April 16th, 2020

RE: Request for Additional Information for Rampart Row Short Plat SPF-20-00001

Marc K. Kirkpatrick
Principal, Encompass Engineering and Surveying

RAMPART ROW SHORT PLAT

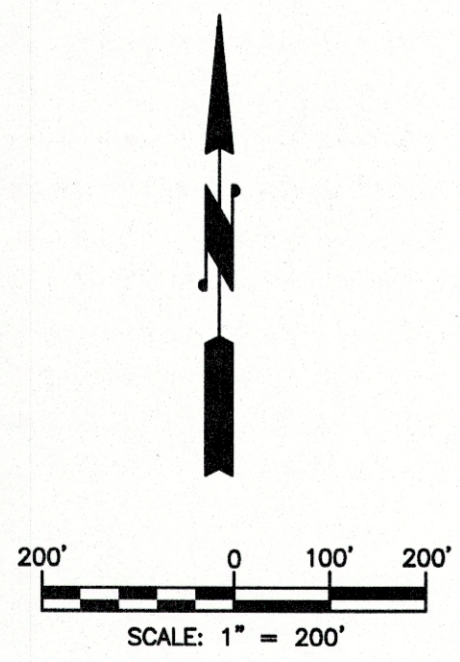
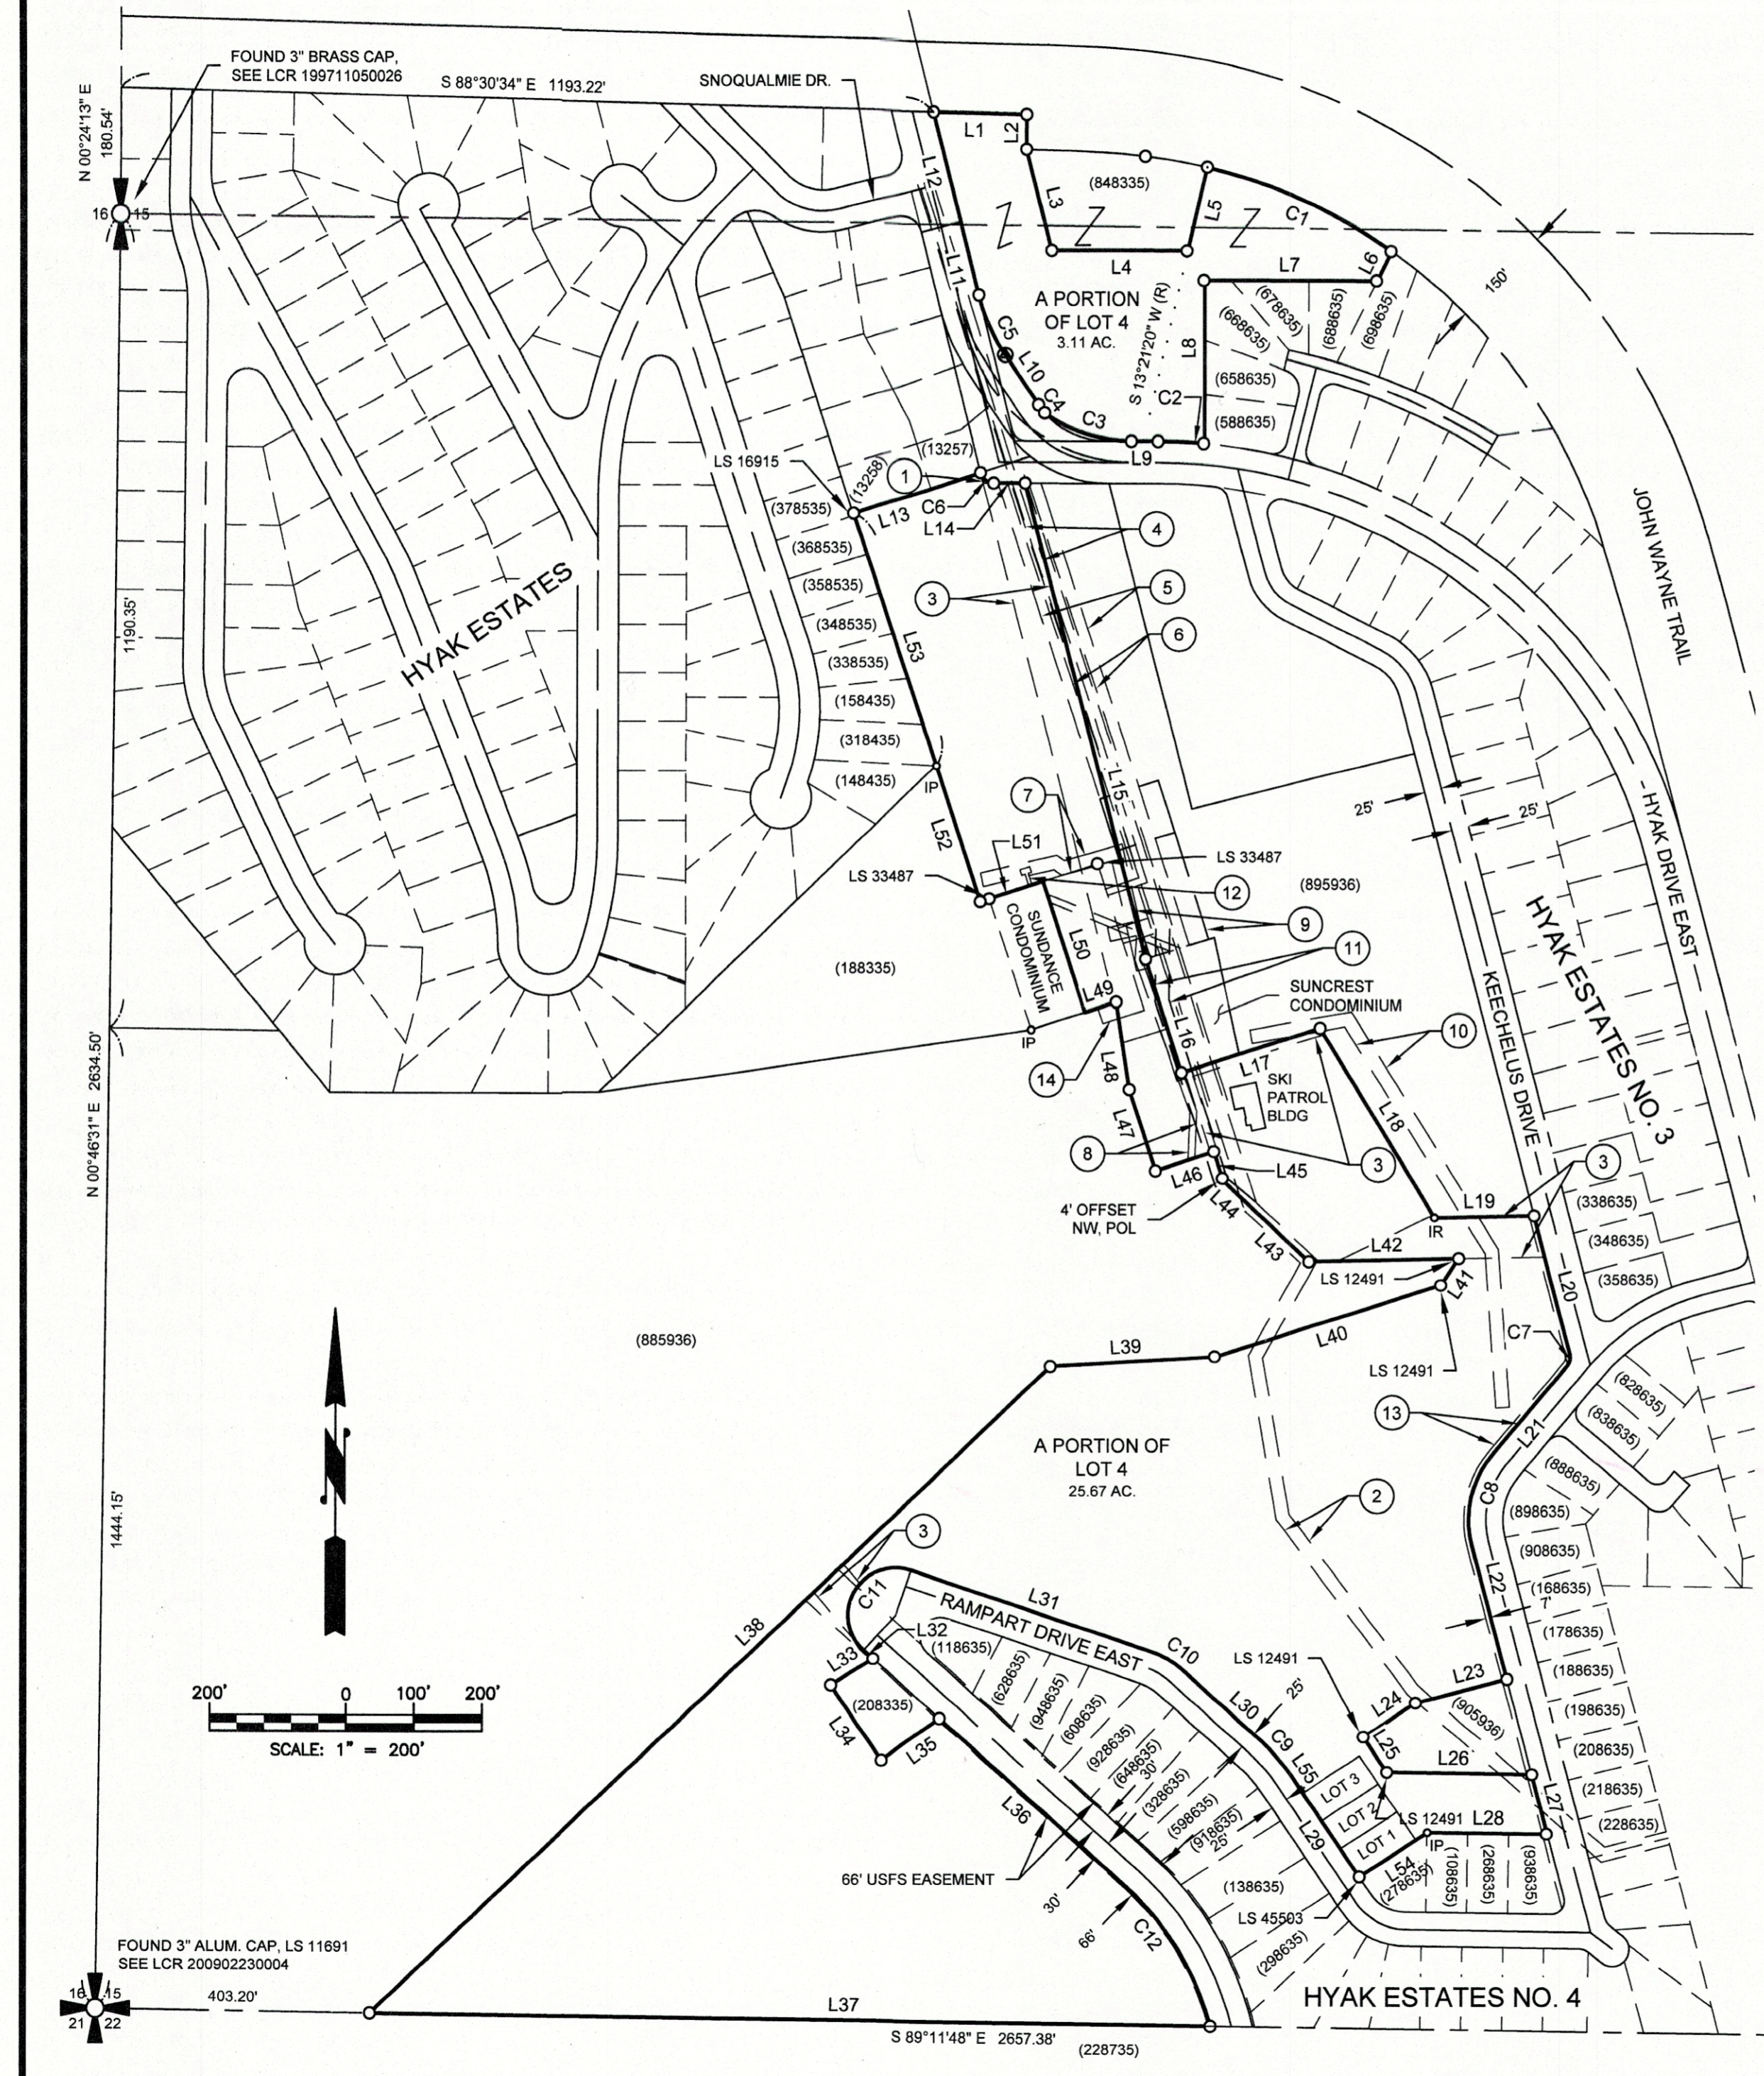
Community Development-Planning

- **The final short plat number SPF-20-00001 has been placed on the final mylar below the original short plat number of SP-19-00002.**
